SUBMISSION REGARDING STATE SIGNIFICANT DEVELOPMENT APPLICATION (SSDA) SSD-80441462

City West Housing **OBJECTS** to Application No SSD-80441462 for proposed Main Works for a mixed-use development with concurrent rezoning located at 881-885 Bourke Street Waterloo (Site) for the reasons following.

Appendix A2 - Solar Access

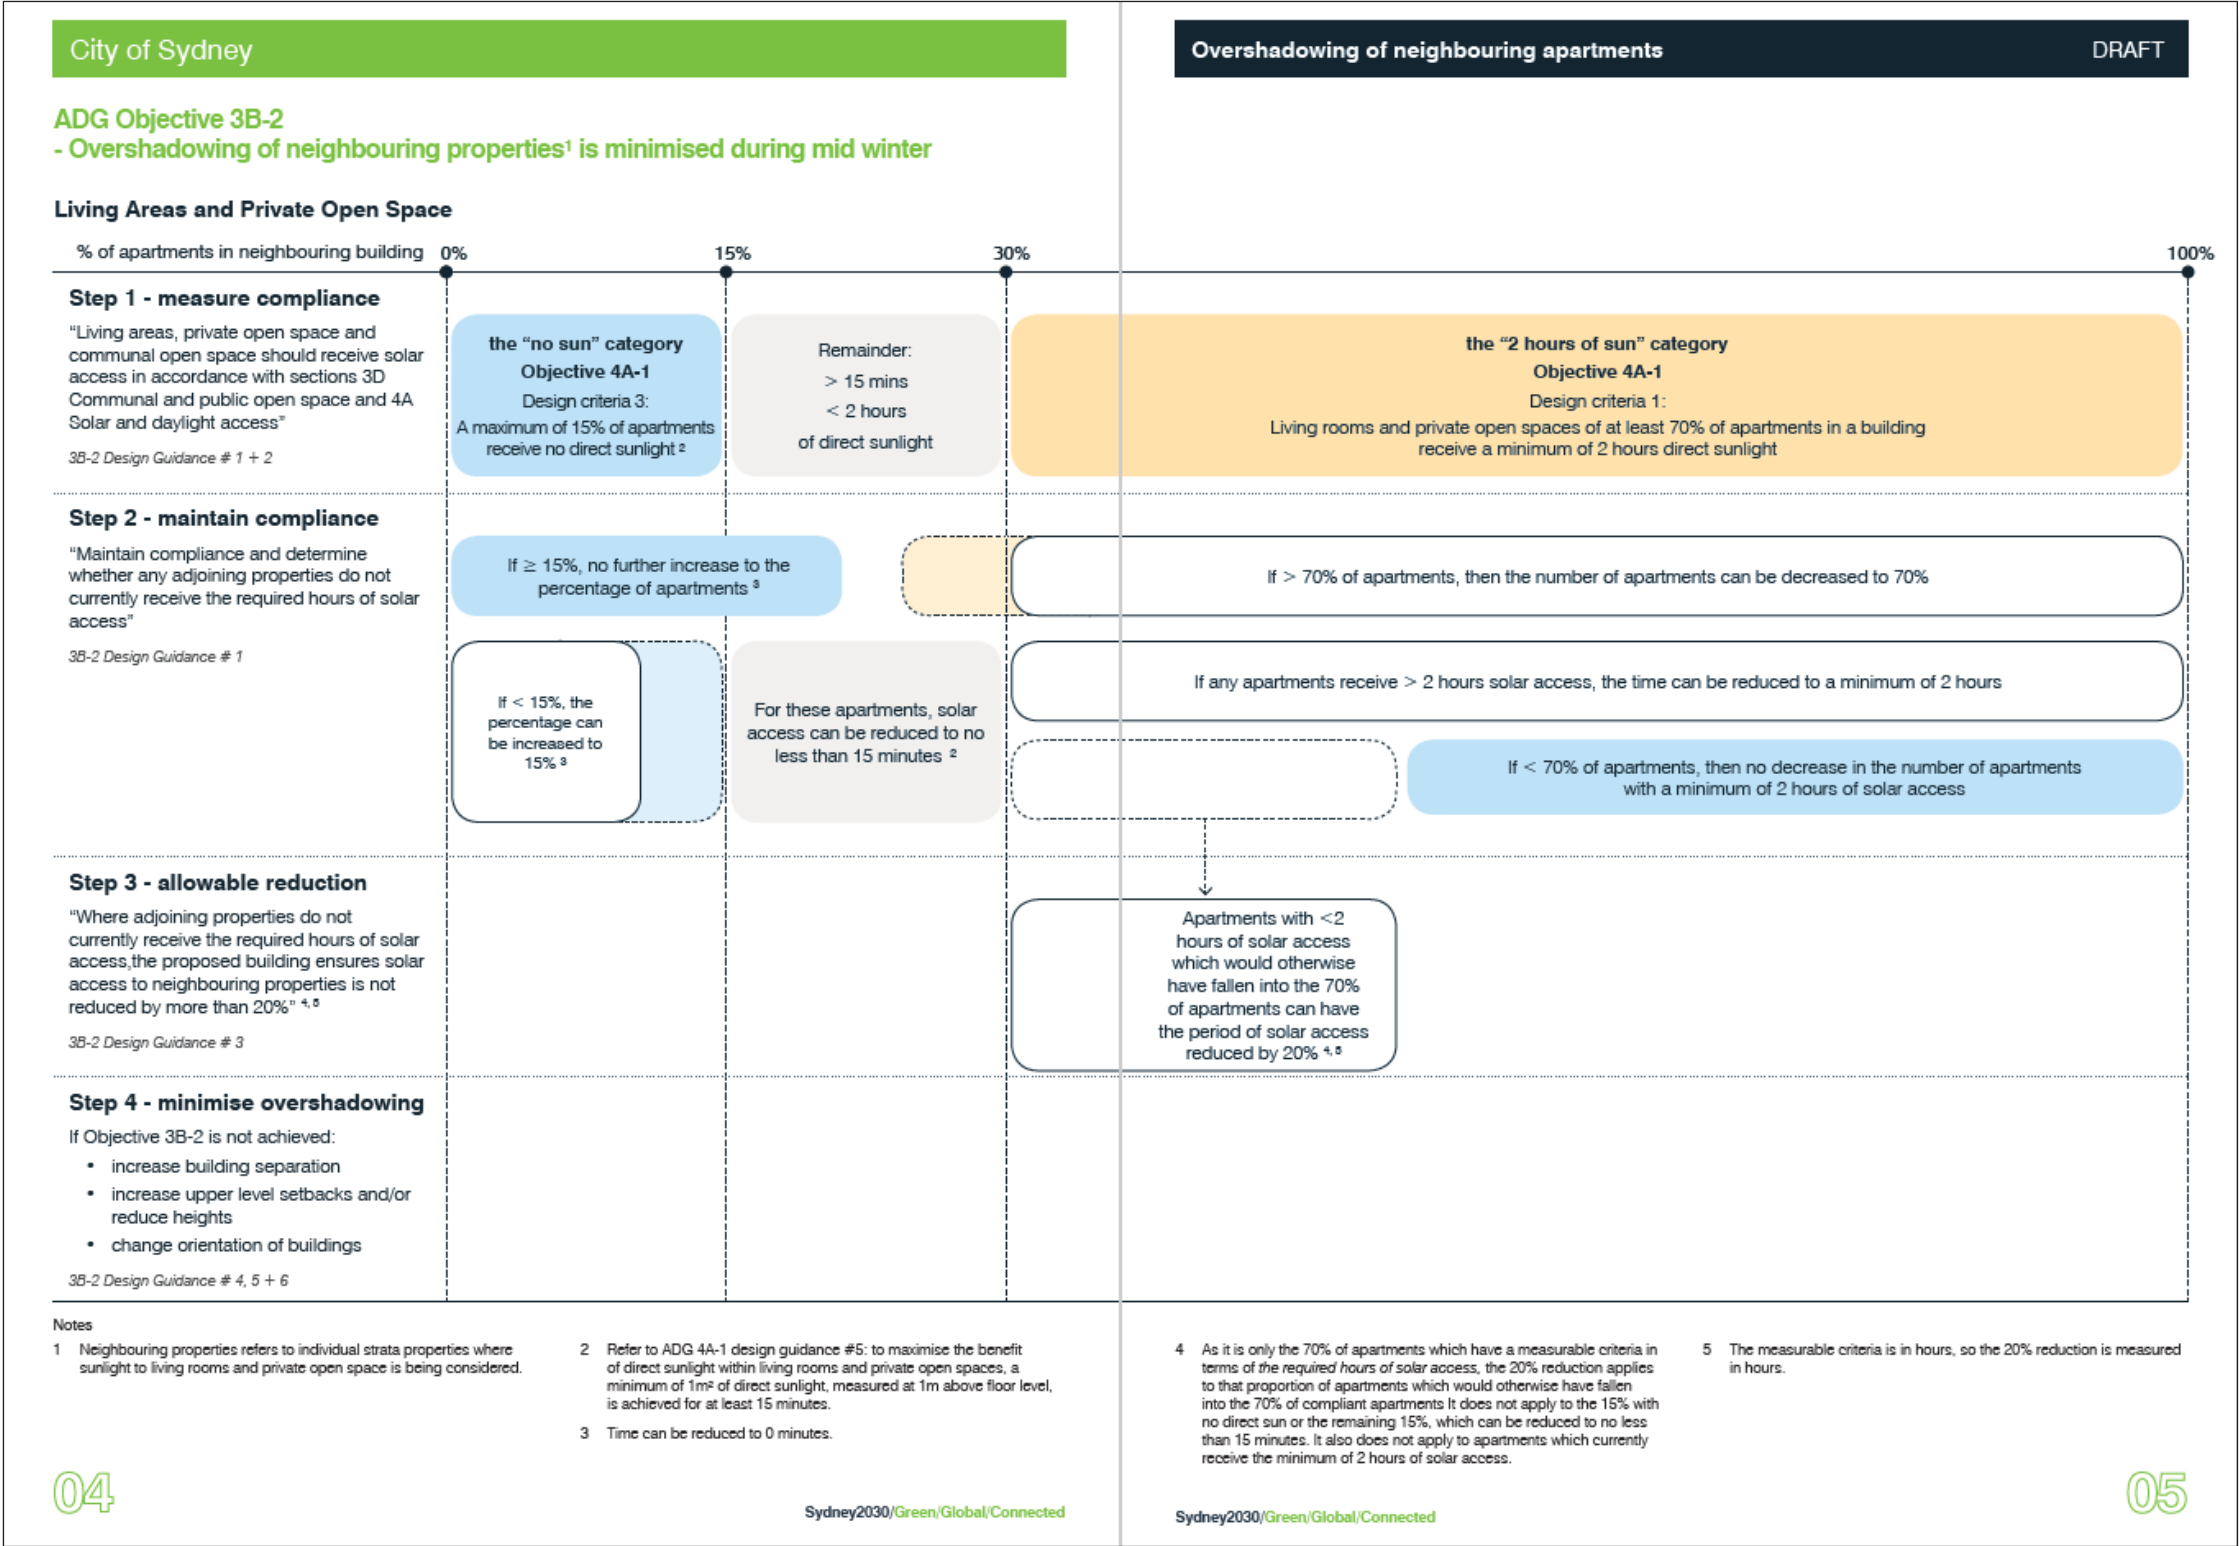
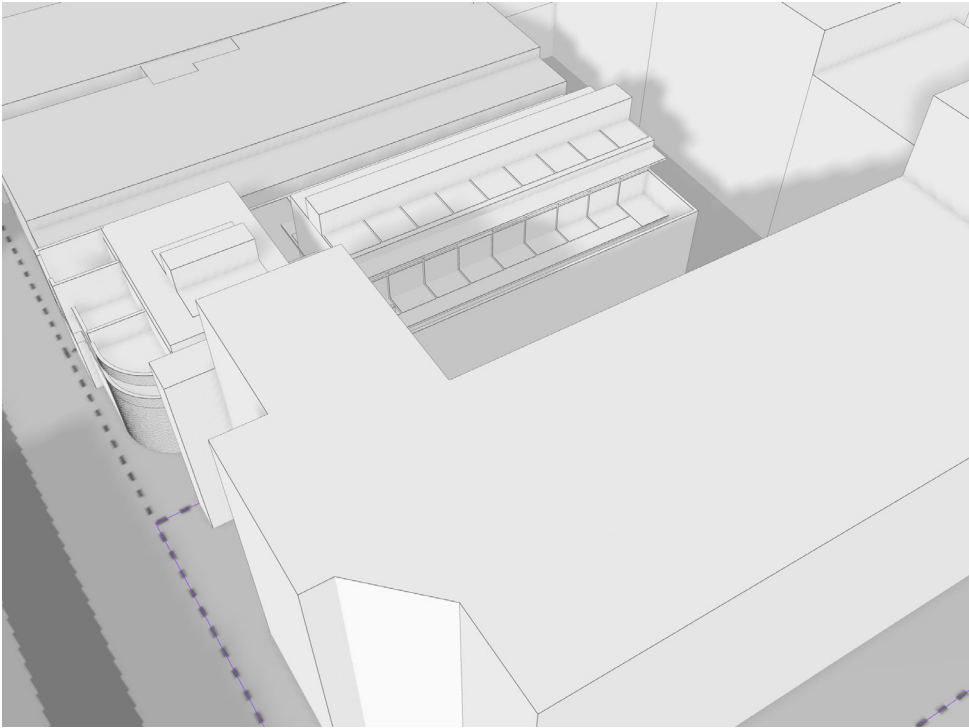
The shadow overlay diagrams in *Appendix E3 Architectural Design Report A2 Solar Access* demonstrate that the northeast block of Boronia Apartments will no longer achieve solar access until 12pm whereas before it was achieving solar access from 9am.

Initial analysis on privacy and overshadowing indicates that the 35-storey tower creates direct overlooking to an arrangement of windows on the northeastern elevation of Boronia Apartments with these windows looking directly into the kitchen and living rooms of these 3-bedroom apartments.

On this basis, a reconsideration of the distribution of GFA across the Applicants site is requested given that the overshadowing appears to be burdening neighbouring sites rather than the development taking its share of overshadowing impacts.
